Subject: RE: BE/92/20/DOC - Babsham

I hope your well and don't mind me emailing directly. I have been asked to clarify your queries regarding my report for Basham farm: BE/92/20/DOC. for convenience have copied your concerns below and my response is below:

Figure 1: Site location plan

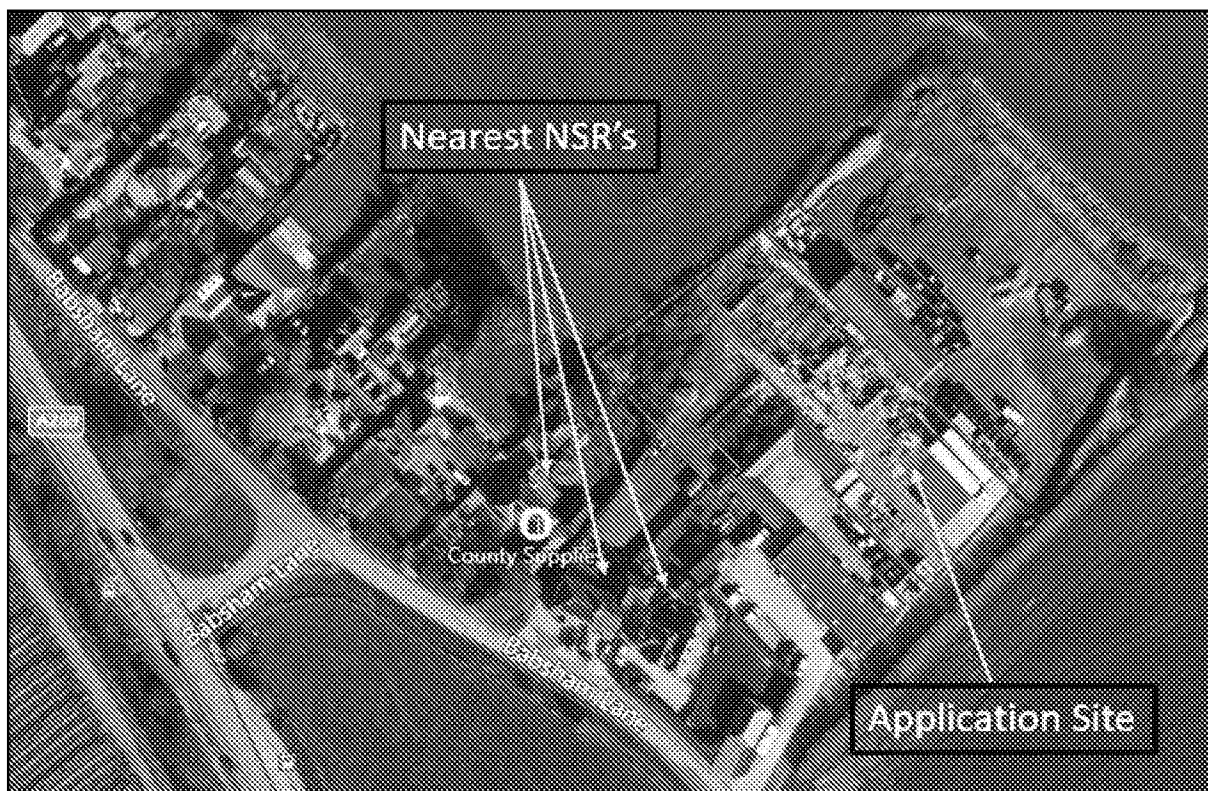
- *Paragraph 3 states that "a sound survey was conducted at the site at a location near to the closest NSR to establish the current background level". Could the applicant please clarify the exact location of the microphone in comparison to the NSR's?*

I have updated figure 1 in the report to show the position of the sound survey compared to the NSR's. A photo of the survey where you can see the NSR's is also shown in figure 3. In terms of measurements, it was at the nearest securable position owned by the client, which was approximately 5m from the boundary of the site. The microphone height was 3m.

Figure 6: L_{A90} statistical analysis including data from when the site was in use

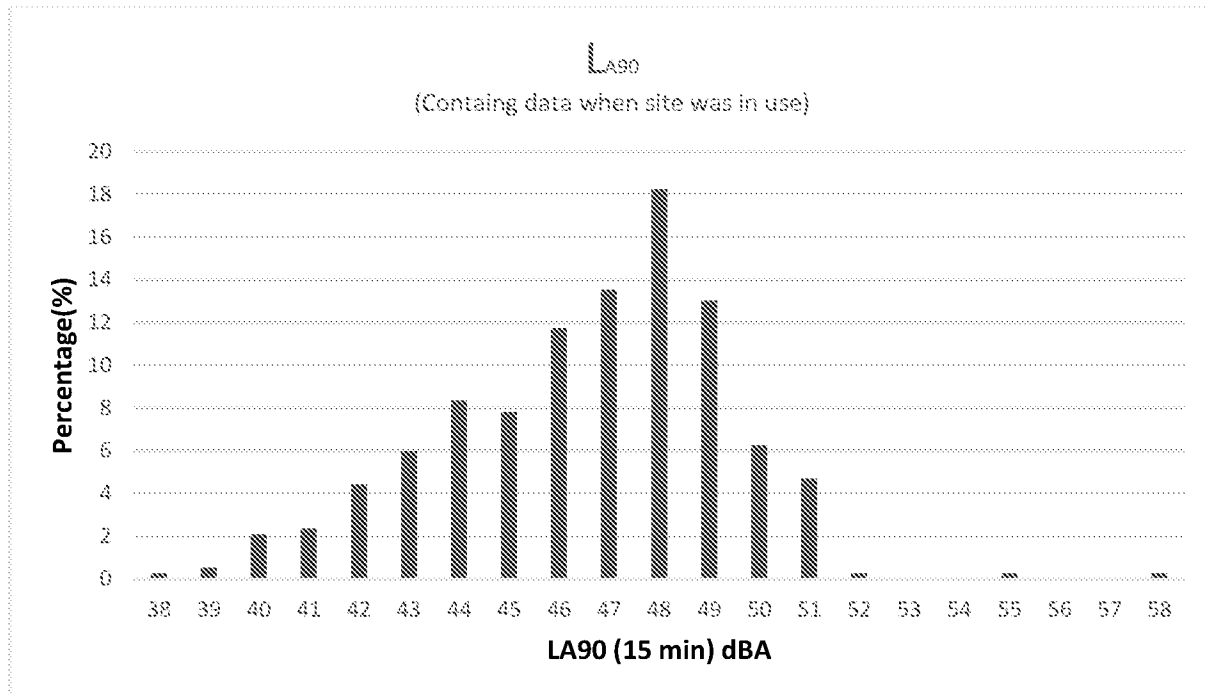
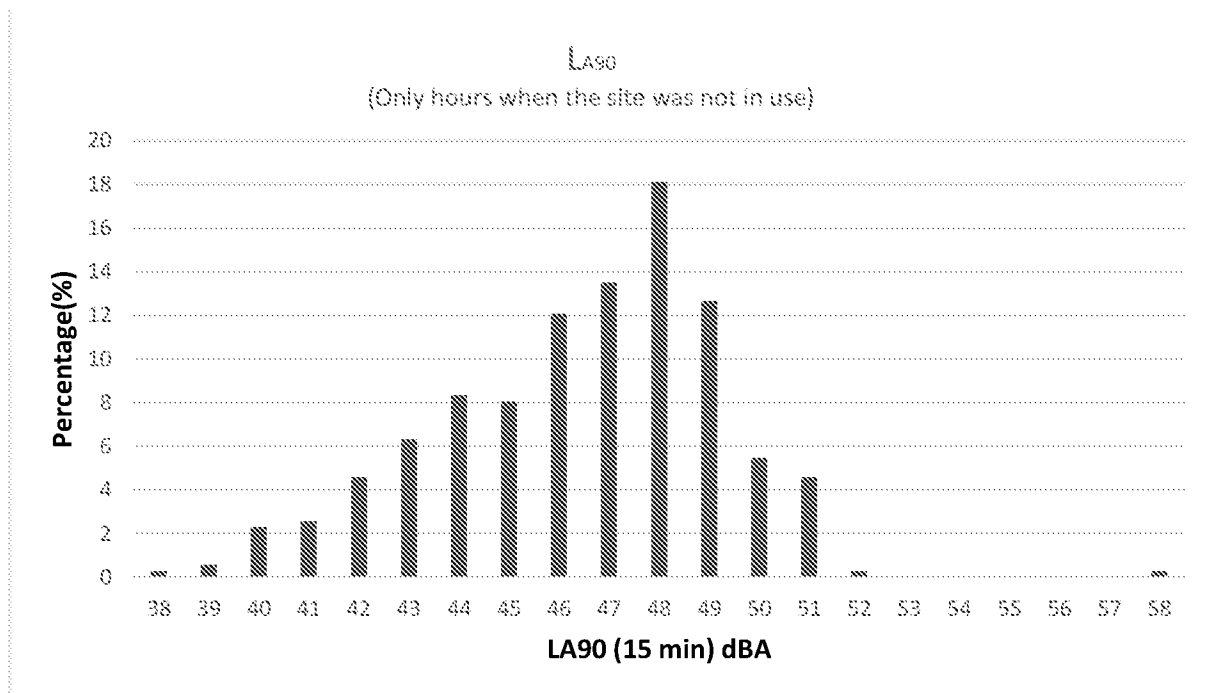
- *The last paragraph in section 5.4 states "there is an obvious dominant sound level at the site" and also "these results would imply the dominant noise source at the site is coming from fixed plant running at a steady level" and finally "undefined fixed plant equipment in the unit behind the application site". Please could the applicant clarify whether or not this paragraph effectively means that "there is an obvious dominant sound source coming from fixed plant which is **not** in the application site"?*

This is correct, I've been to site 4 times and each time the soundscape was dominated by a piece of undefined equipment in the site behind the application site. I did enquire as to what the equipment was from the company who use that site, however, I wasn't greeted with a helpful response. I would guess it was a generator of some kind, but this is a guess.

Figure 12: Worst-case house noise model

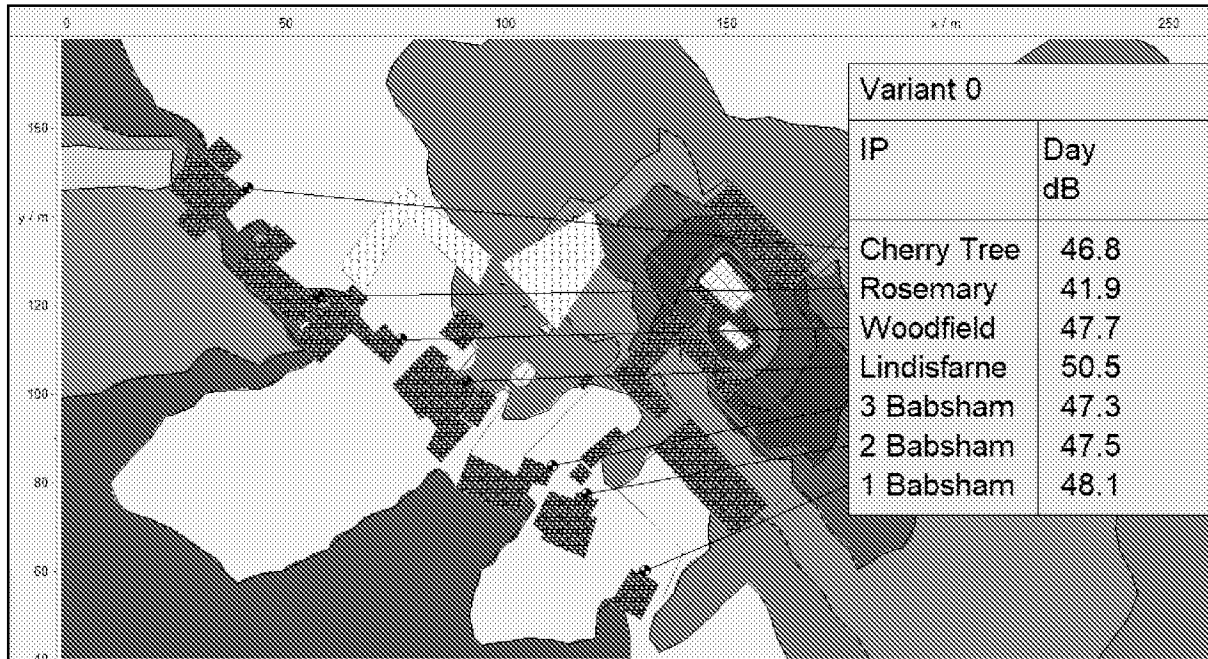
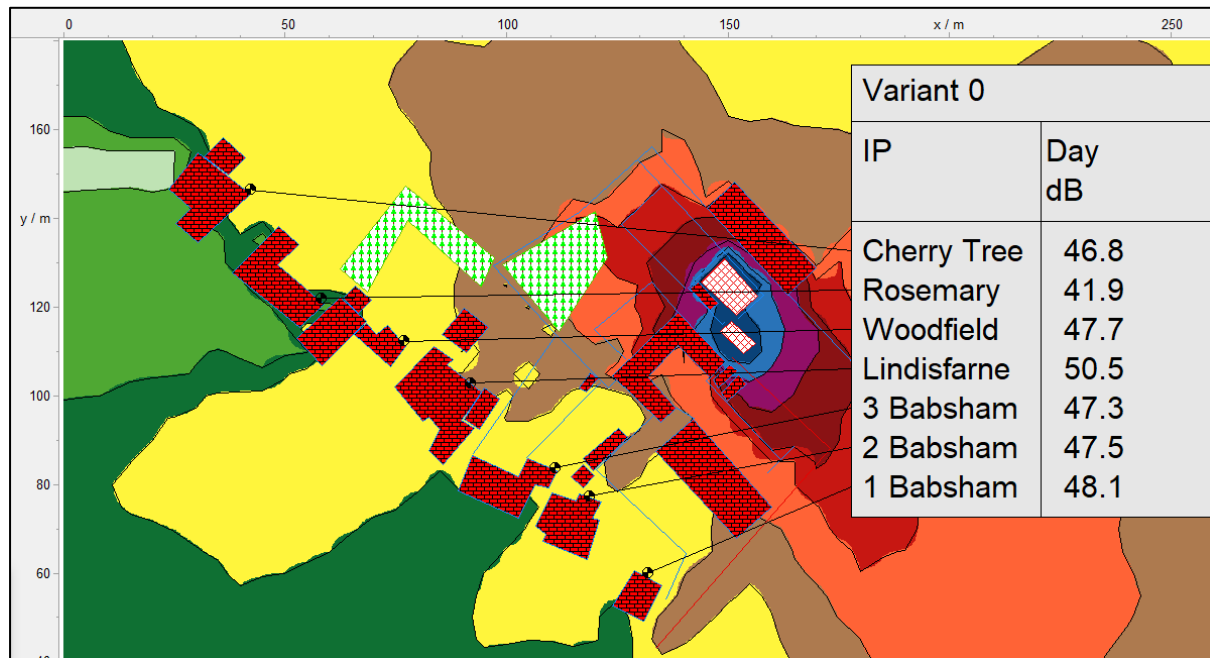
Figure 12 – thanks for the colour document. I think our Planning department scan in black and white as it would not be prudent to scan all planning apps in colour.

- *Please could Figure 12 be provided in colour?*

Of course, it should have been in colour in the original report so I'm not sure how you got it in black and white, but it is in colour in the report attached and I have included a sperate attachment of just that image.
